Consultation Response from KC,
Highways Development Management

2023/93076 former Lloyds Bank, 22, Carr Lane, Slaithwaite, Huddersfield, HD7 5AN

External alterations to former bank building to form restaurant and takeaway, installation of extract ventilation system (class Eb) (within a Conservation Area)

Date Responded: 17/01/2024.

Proposed Ground Floor Plan - 1:50

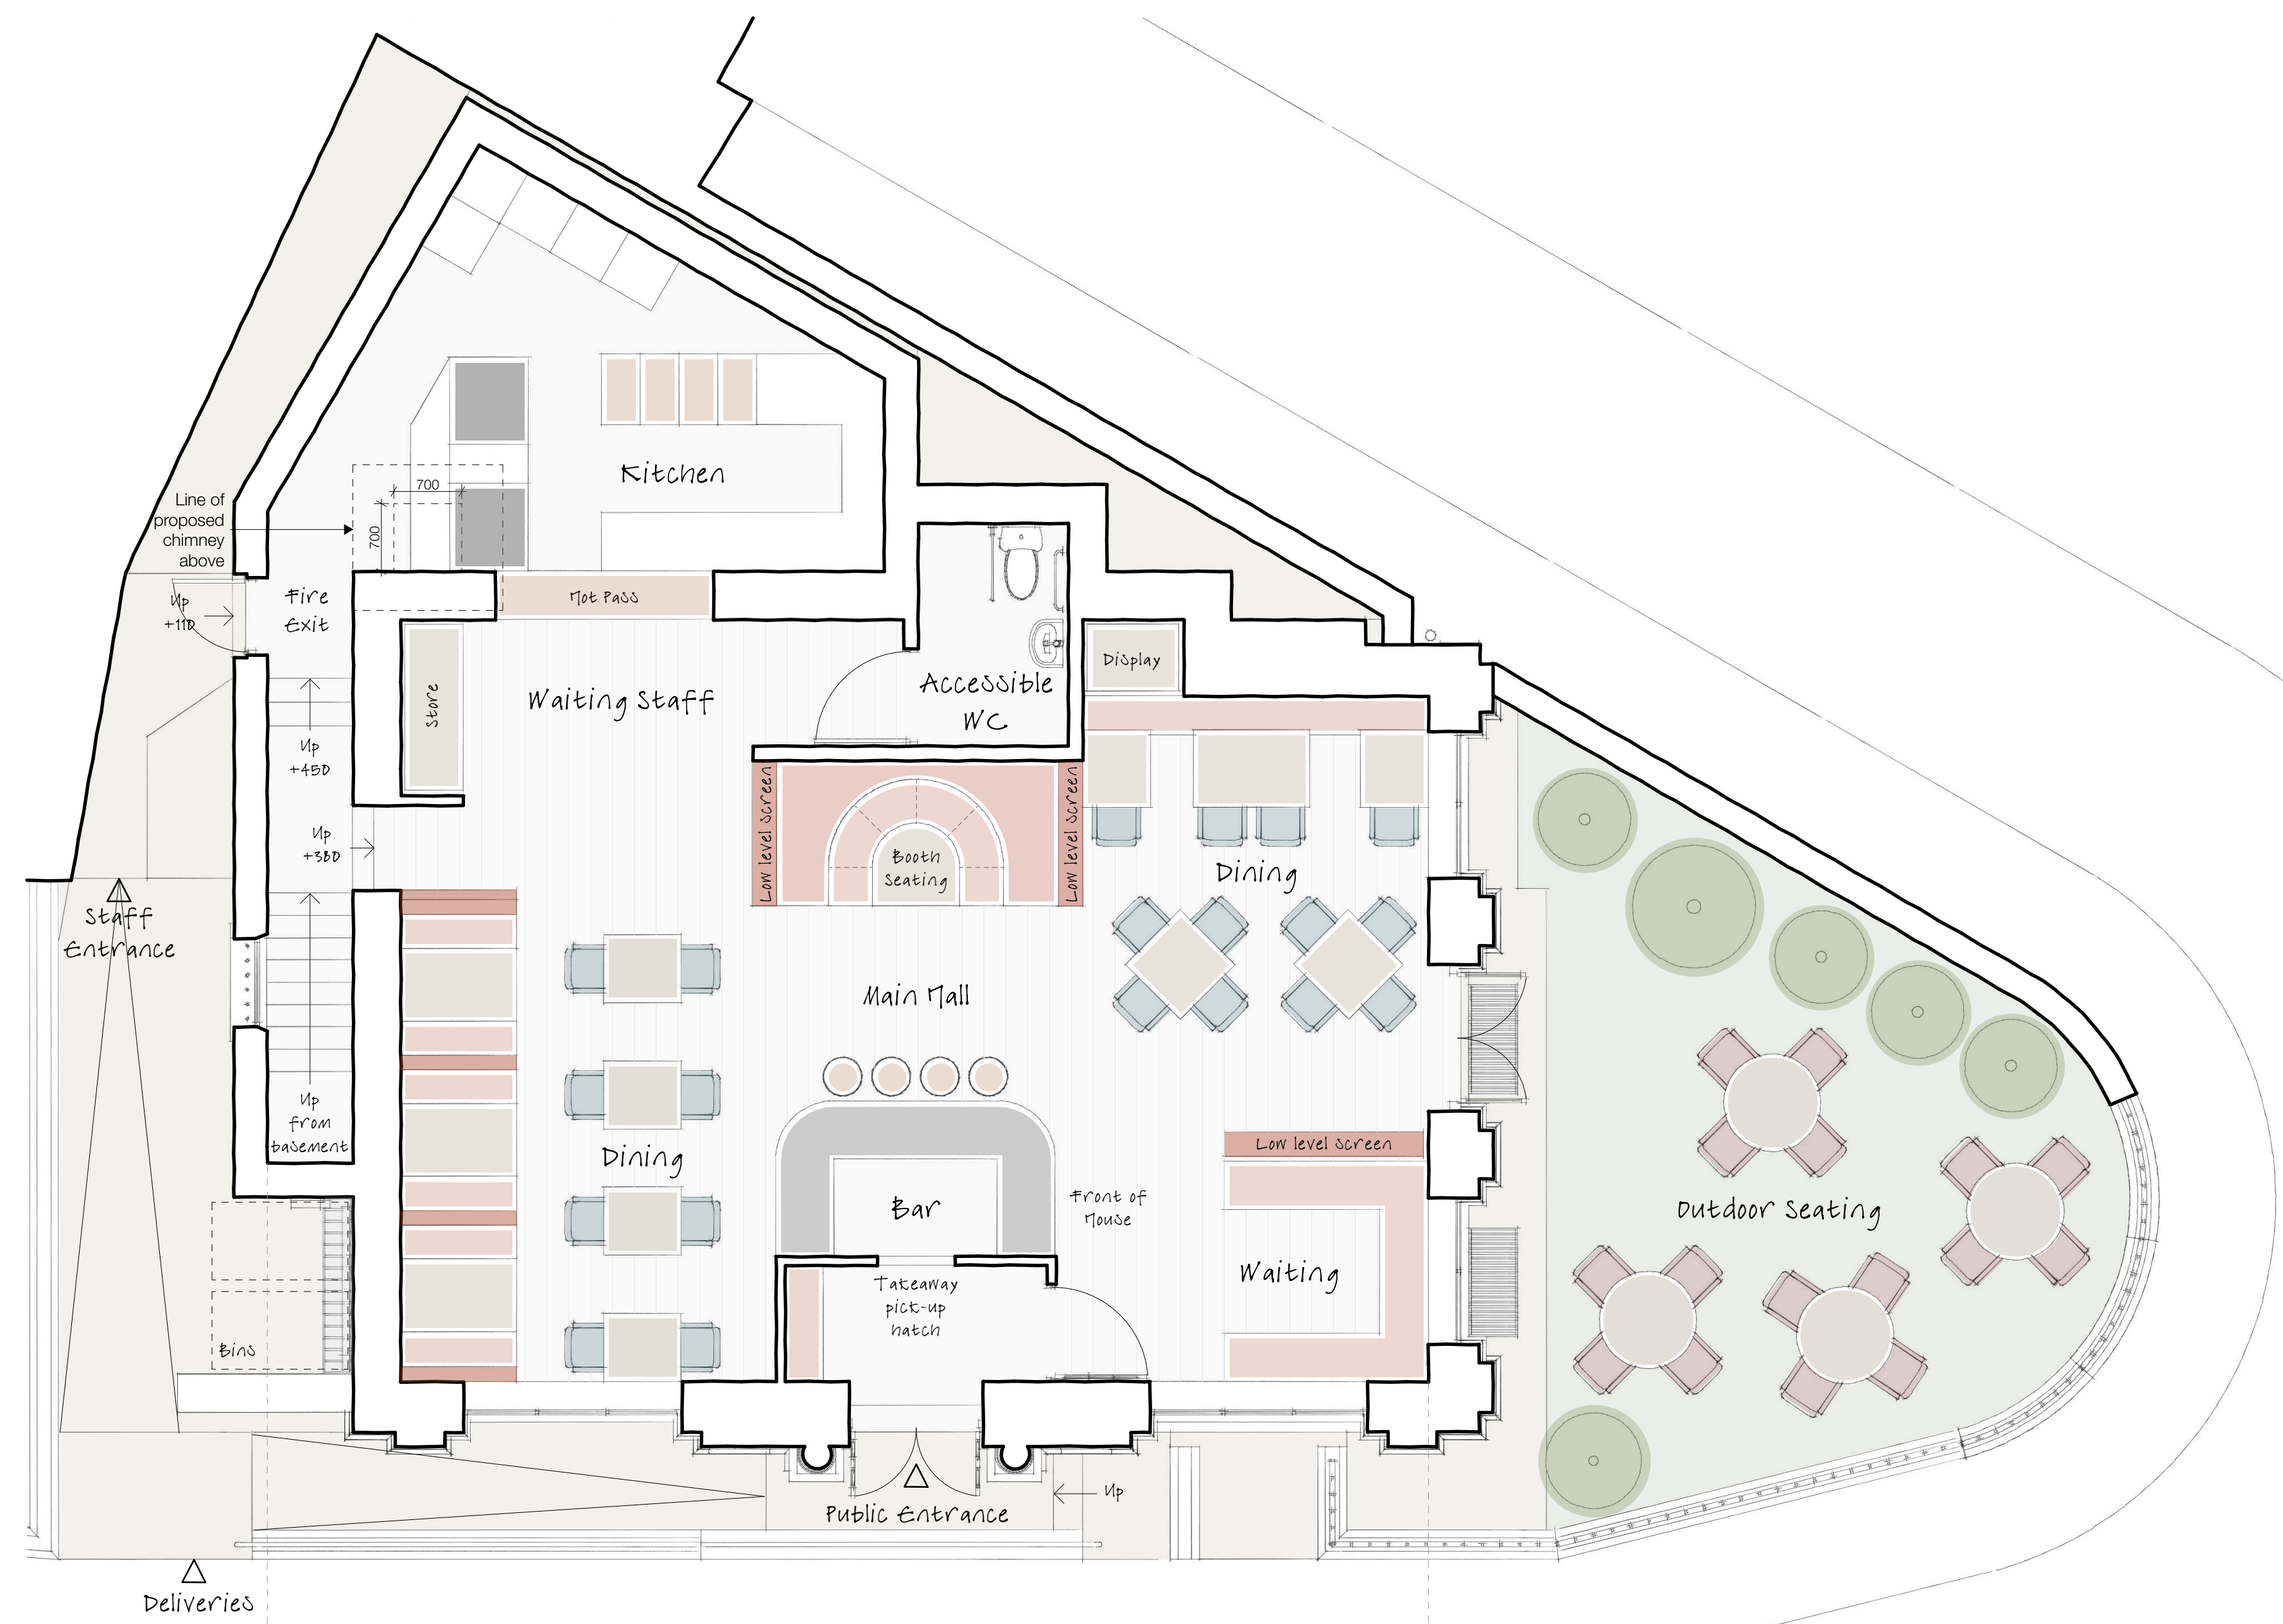
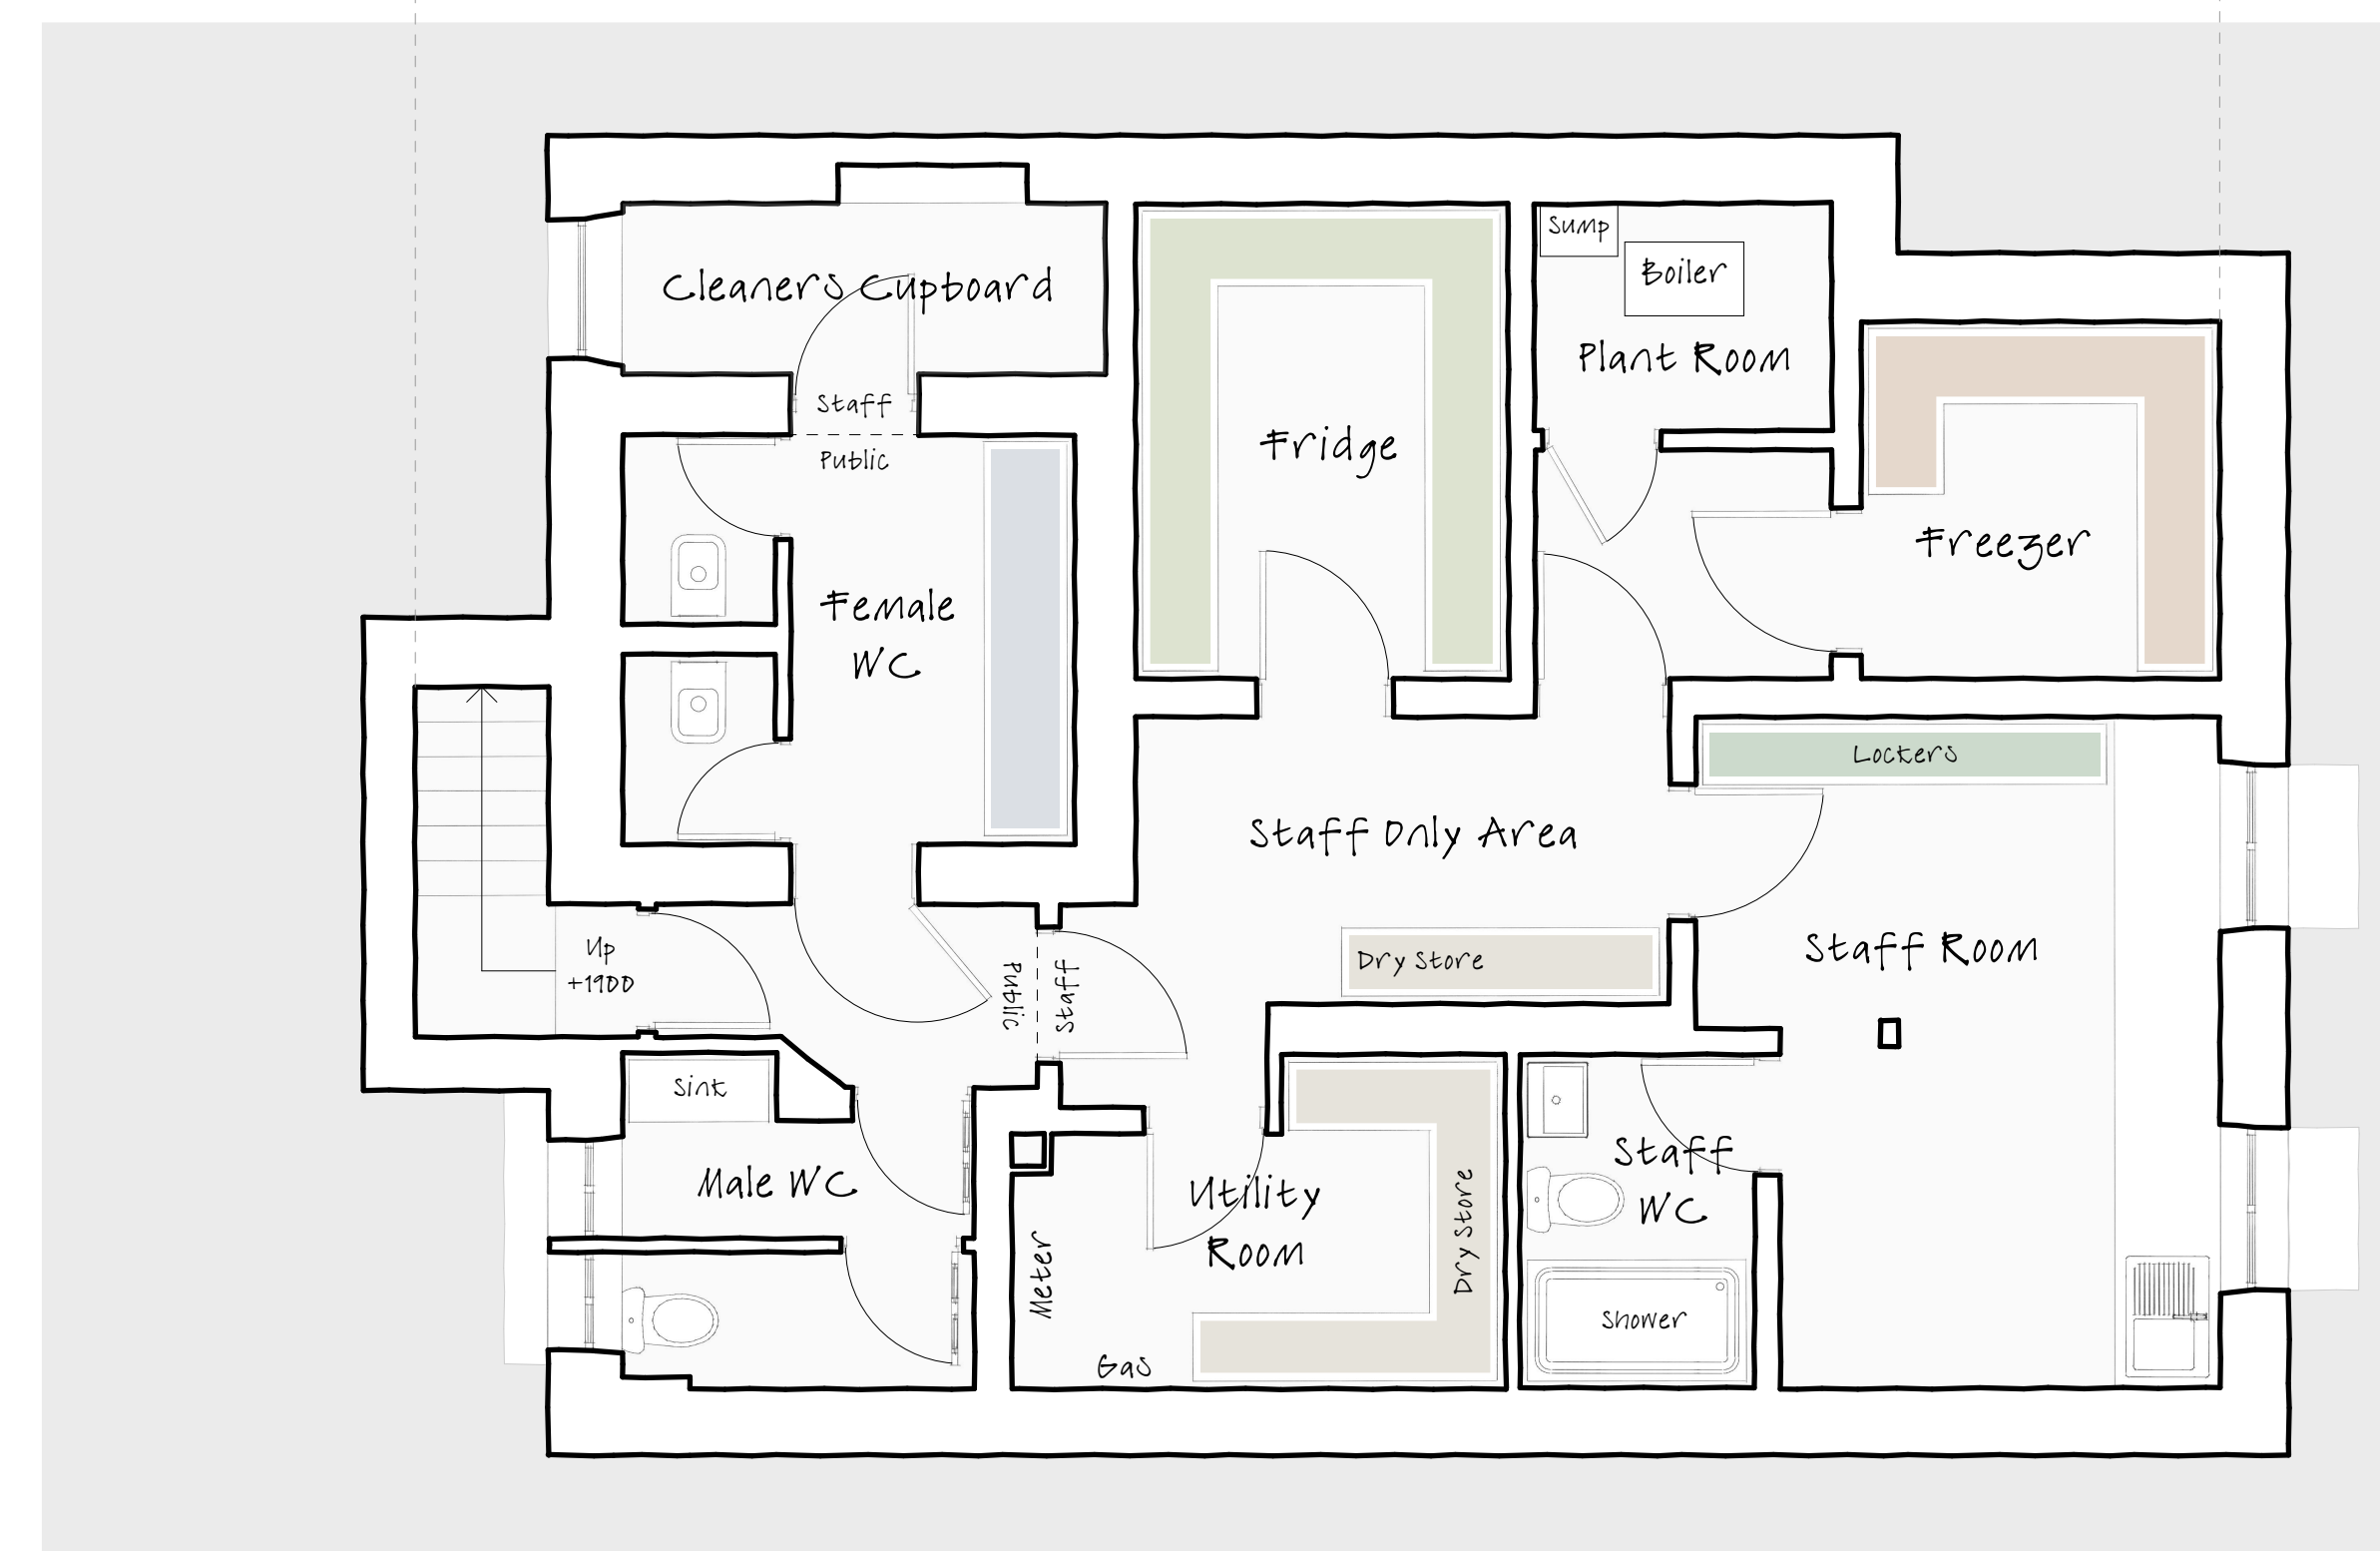
The plans show that deliveries will be taken from the front of the premises on Carr Street, however there is nowhere for delivery vehicles to park safely. The Developer needs to provide more information on how deliveries will be carried out in the form of a delivery management plan.

A bin store is shown on the plan, but, again, there is no information on how waste will be collected. Further information on the collection of waste from the premises is required.
